Your Ref: OWPC26420
Our Ref: AW/66/20/HH 10-03-2020
Please ask for:
Amber Willard

Addition of first floor to convert bungalow to house.

41 Gossamer Lane Aldwick

DRAWING PLANNING DATE: FEBRUARY 2020 DRAWN: T. Murray	SCALE 1/100 REVISION:

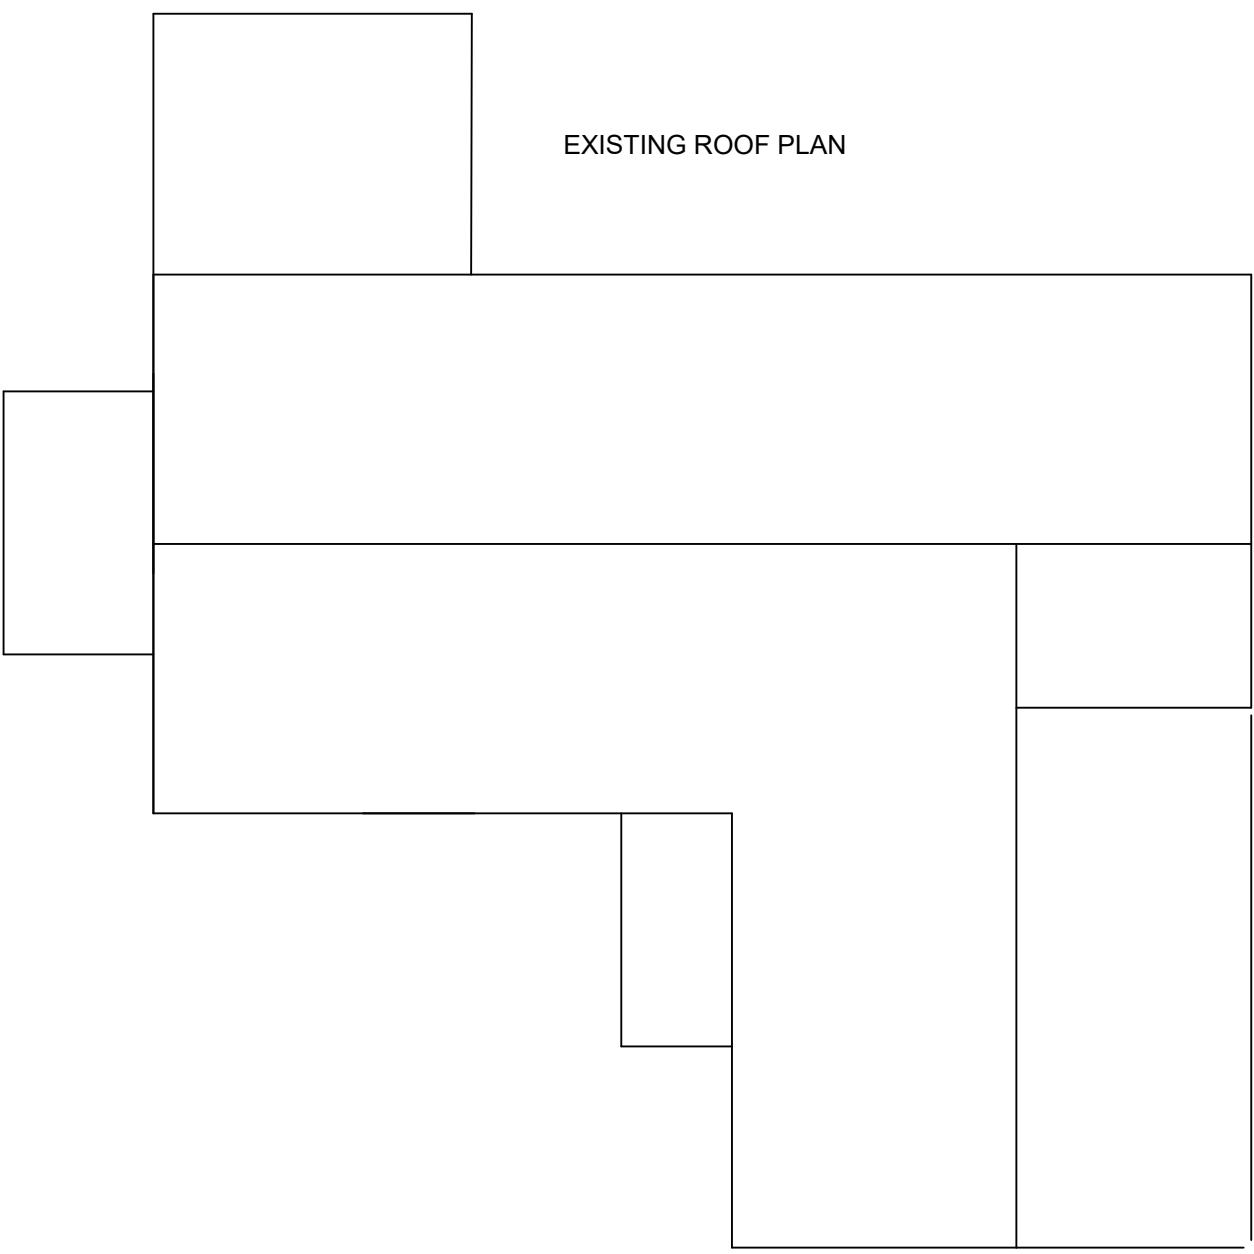
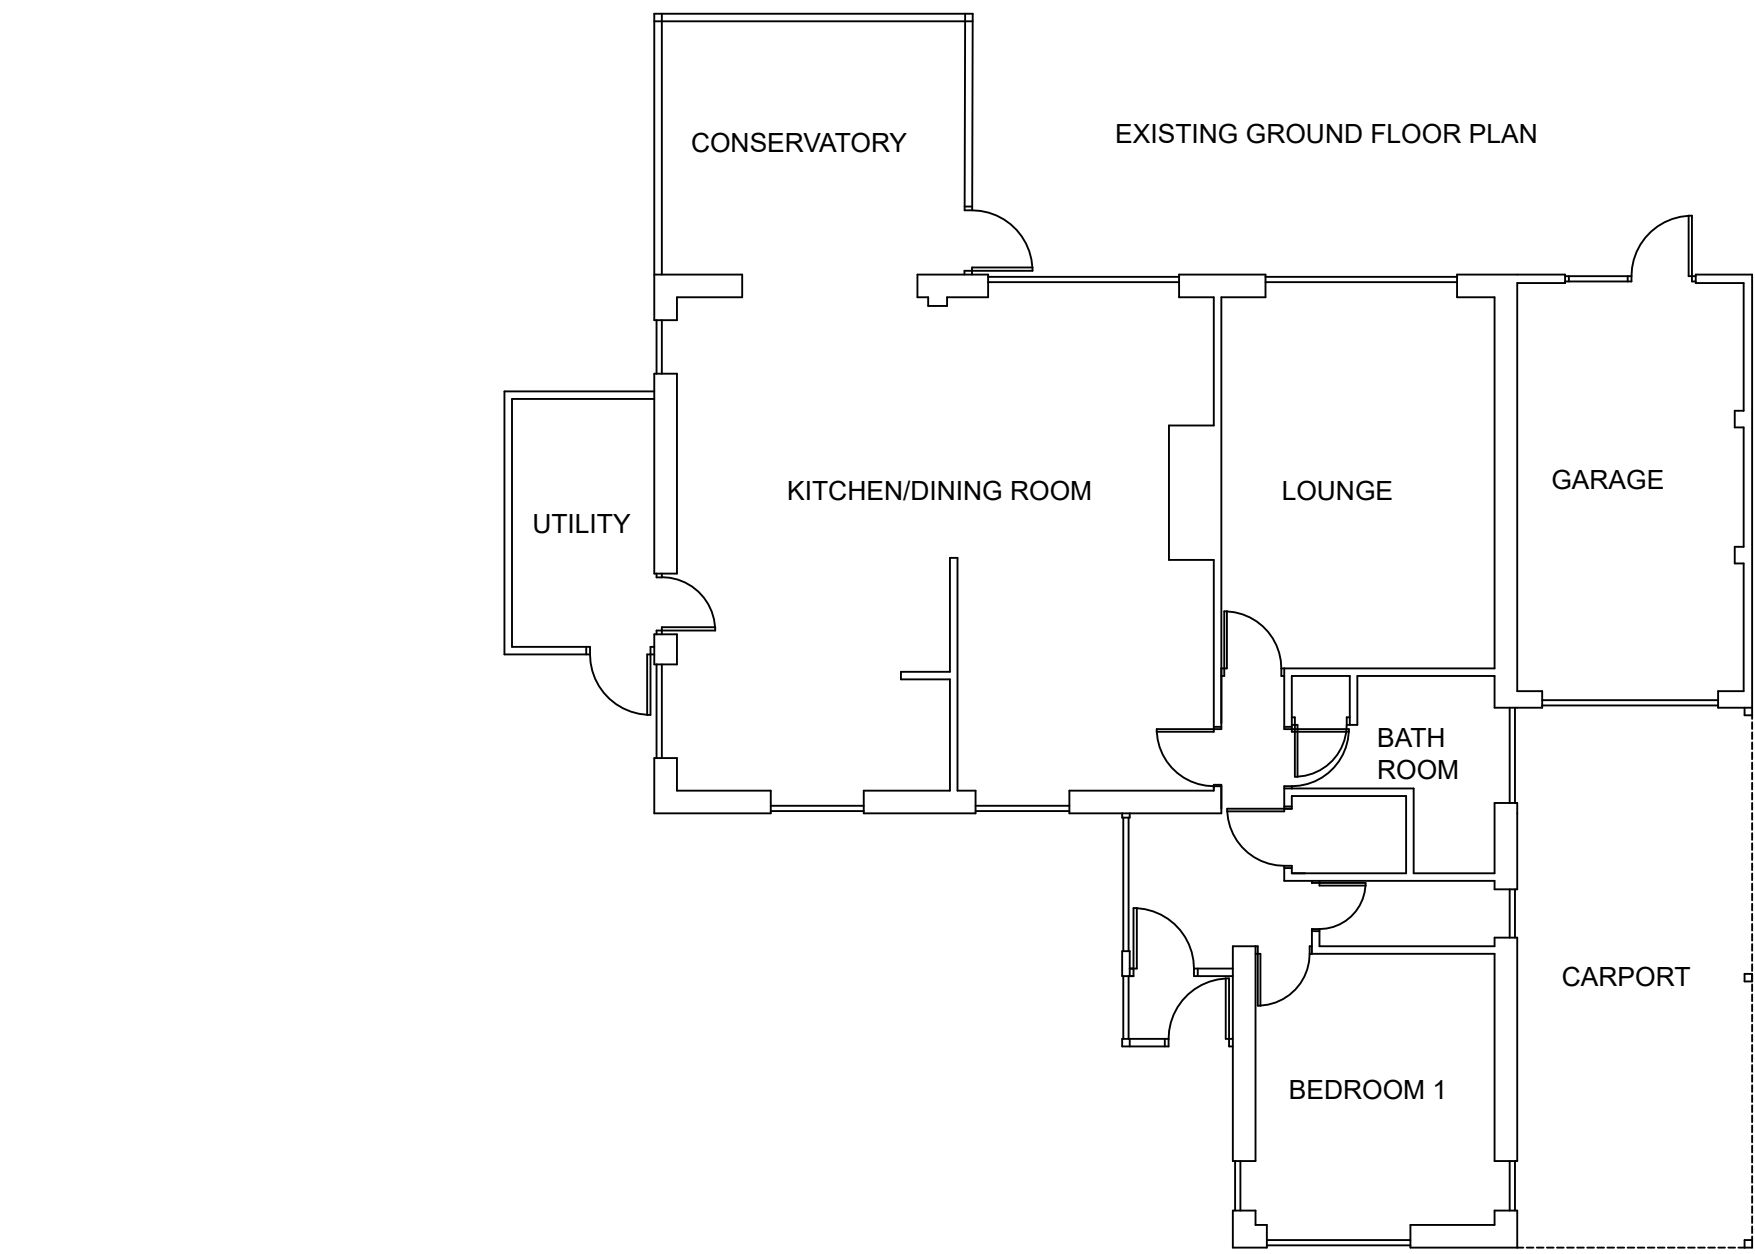
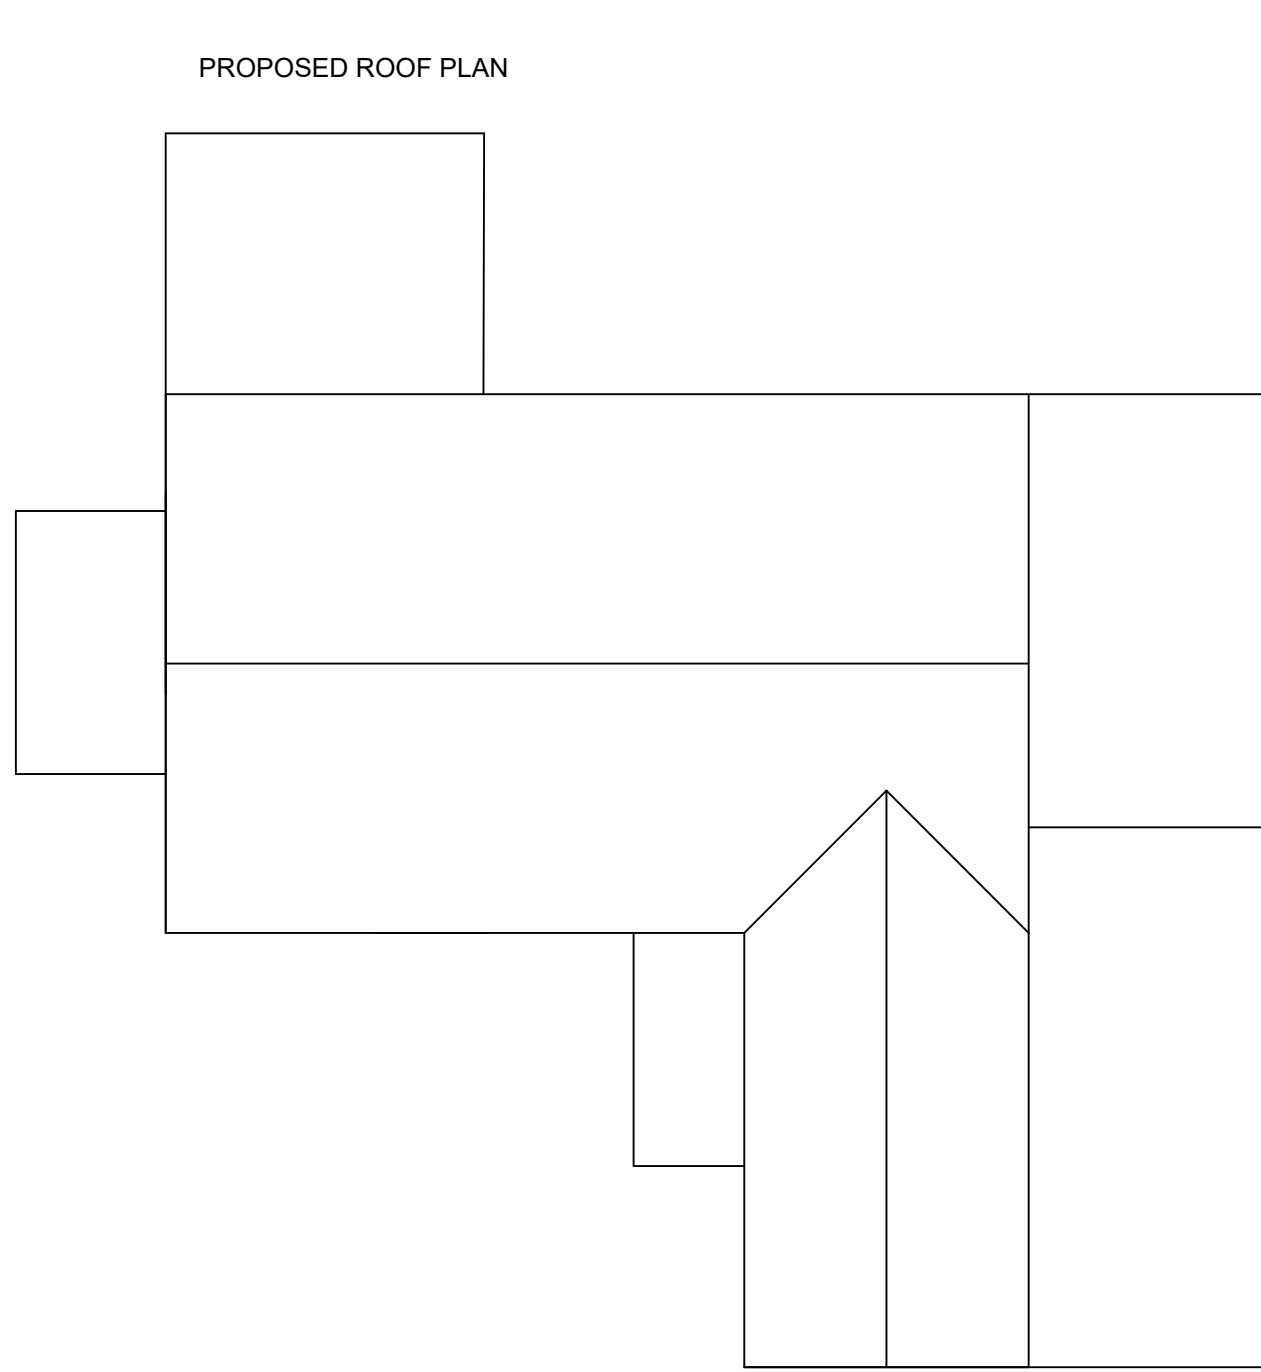
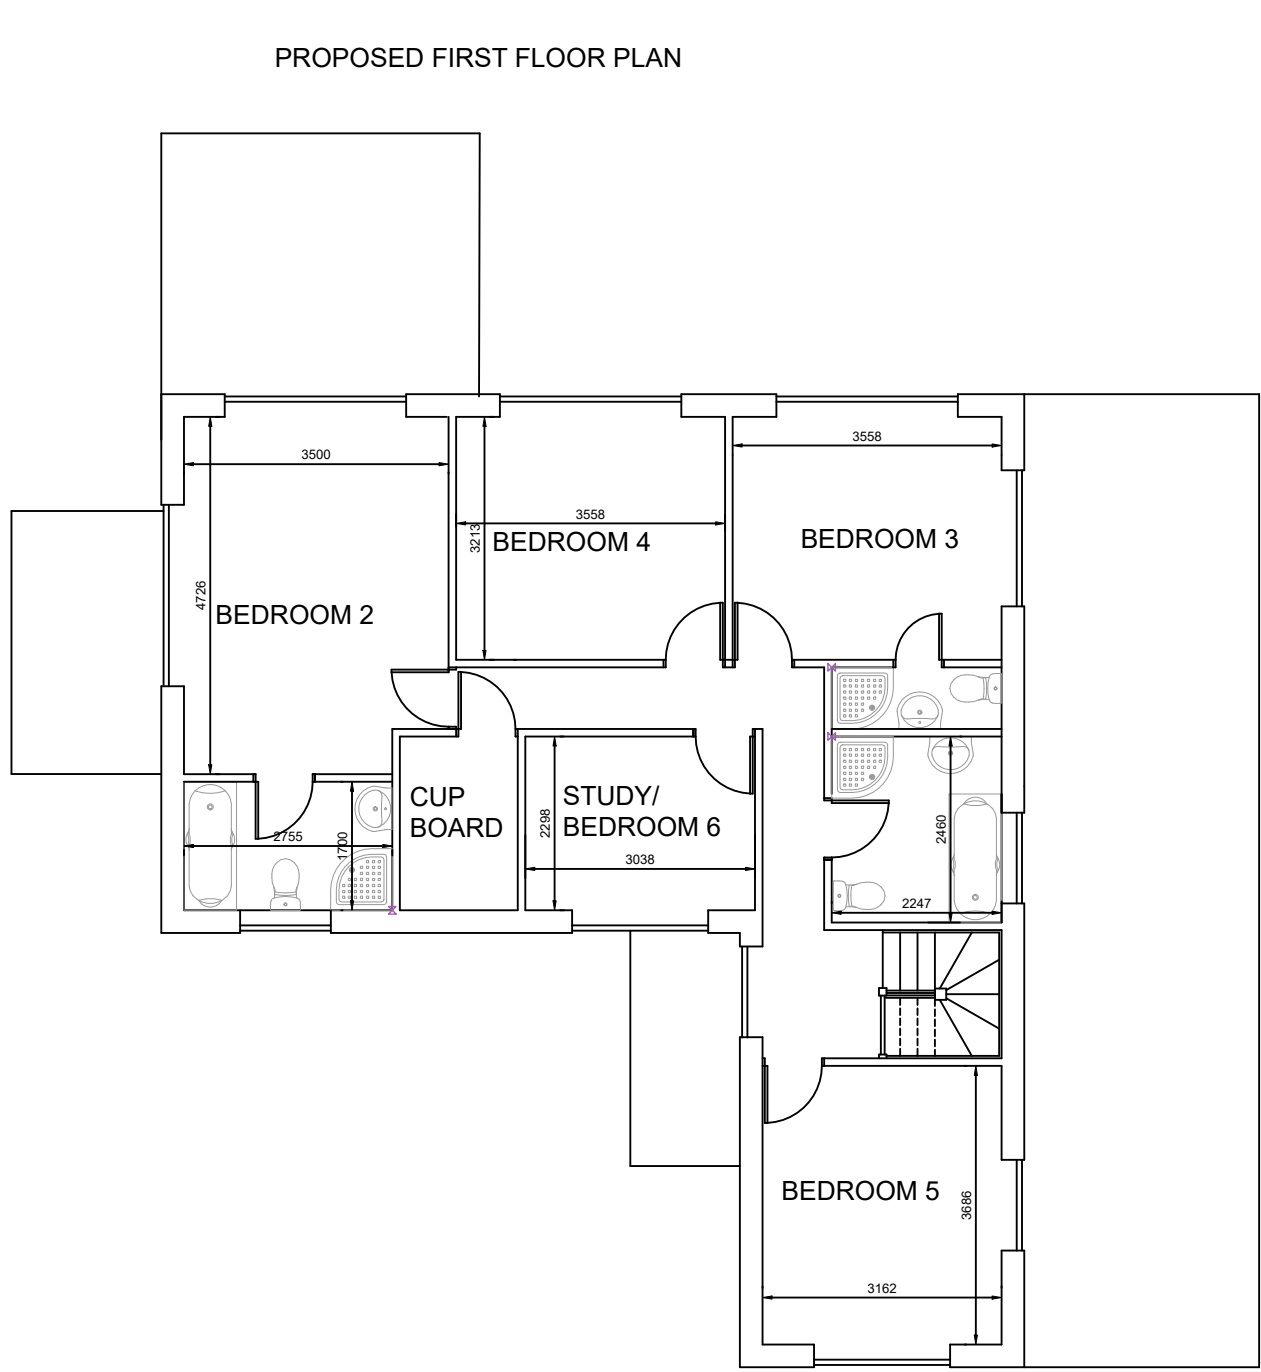
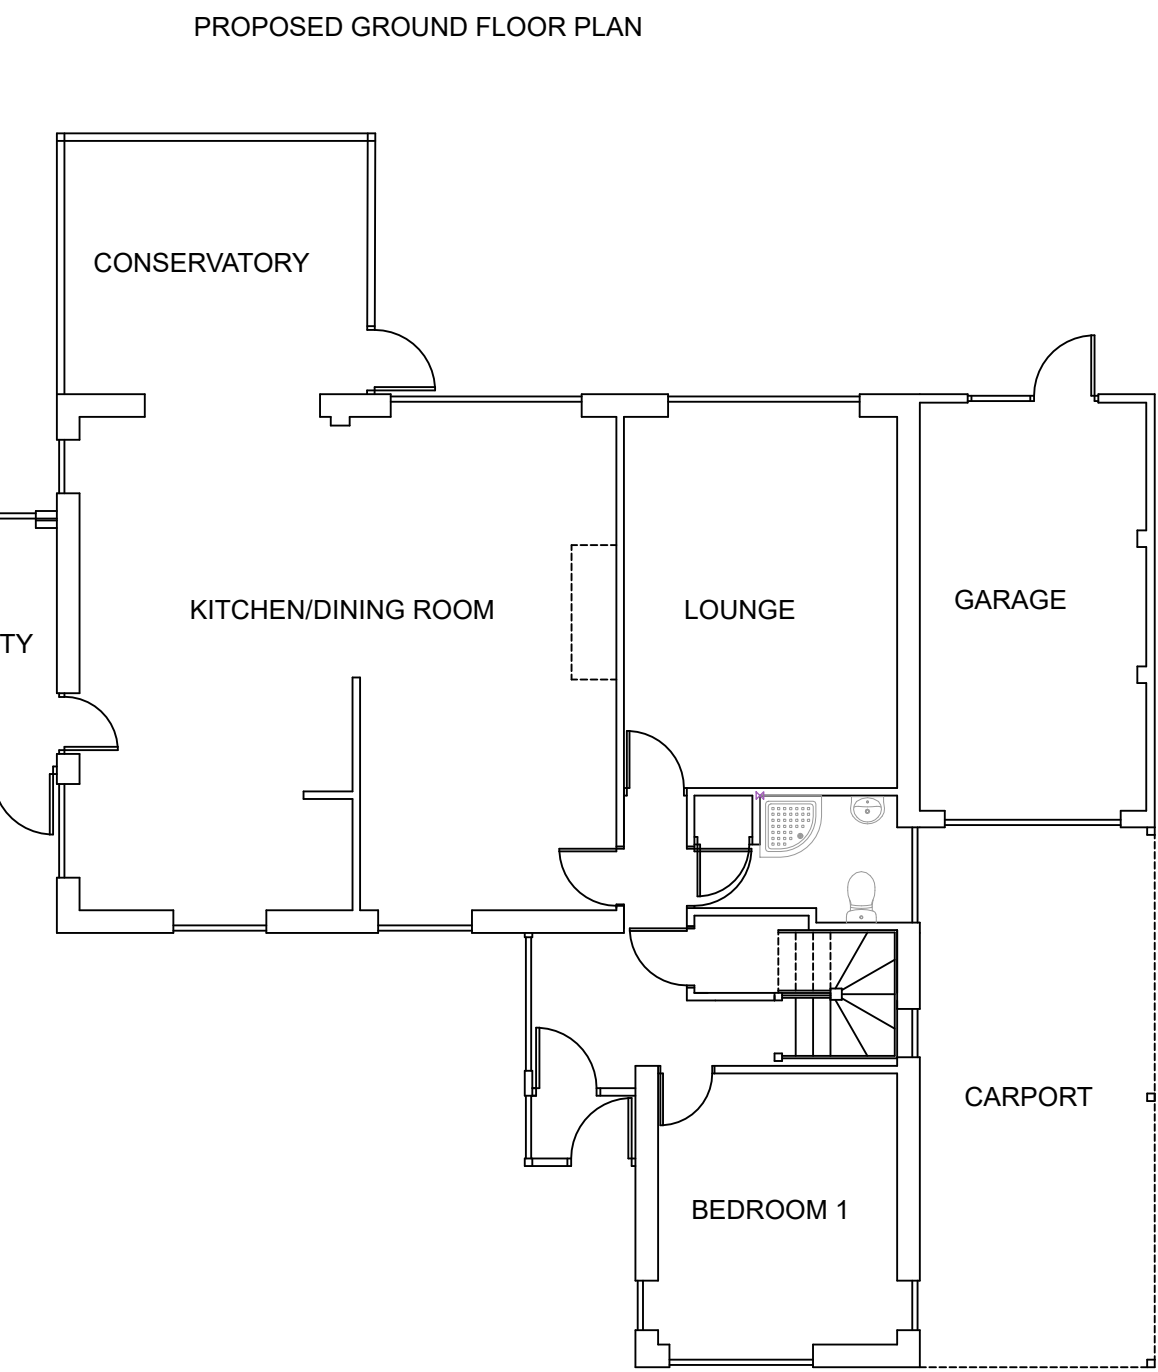
The proposed upper storey to the rear aspect:

The rear aspect of three properties, namely 37, 39 and 41 Gossamer Lane, each comprises a single storey.

The proposed upper storey to the rear aspect of 41 Gossamer Lane, would therefore:

- a. be out of keeping with the style and rear alignment of the adjacent properties.*
- b. spoil the open aspect currently enjoyed in the rear gardens.*
- c. adversely interfere with privacy by overlooking the gardens at 37 and 39 Gossamer Lane.*

The proposed side windows in the upper storey to the rear aspect:

These windows would adversely affect the privacy of:

- a. the next door dwelling, 39 Gossamer Lane.*
- b. the rear gardens of 37 and 39 Gossamer Lane.*

The proposed upper storey to the east aspect:

The proximity of the proposed upper storey on the east side of the bungalow (side adjacent to 39 Gossamer Lane) would be significantly out of character with the neighbouring houses by virtue of reducing the current sense of spaciousness between the properties.

It was for this reason that the plans for the recent extension of 39 Gossamer Lane (re addition of an upper storey above the garage) were amended to include an indented slope to the roof.

- 1. That a limitation is applied to the rear aspect of the proposed first floor extension, regarding both its intrusive height and its windows, in order to maintain neighbourhood privacy and openness.*
- 2. That the plans for the eastern aspect (utility side) are remodelled so as to maintain the distance between the upper storeys of 39 and 41 Gossamer Lane (and preferably including an east-west slope to the roof), and the sense of spaciousness between the properties in this part of Gossamer Lane.*
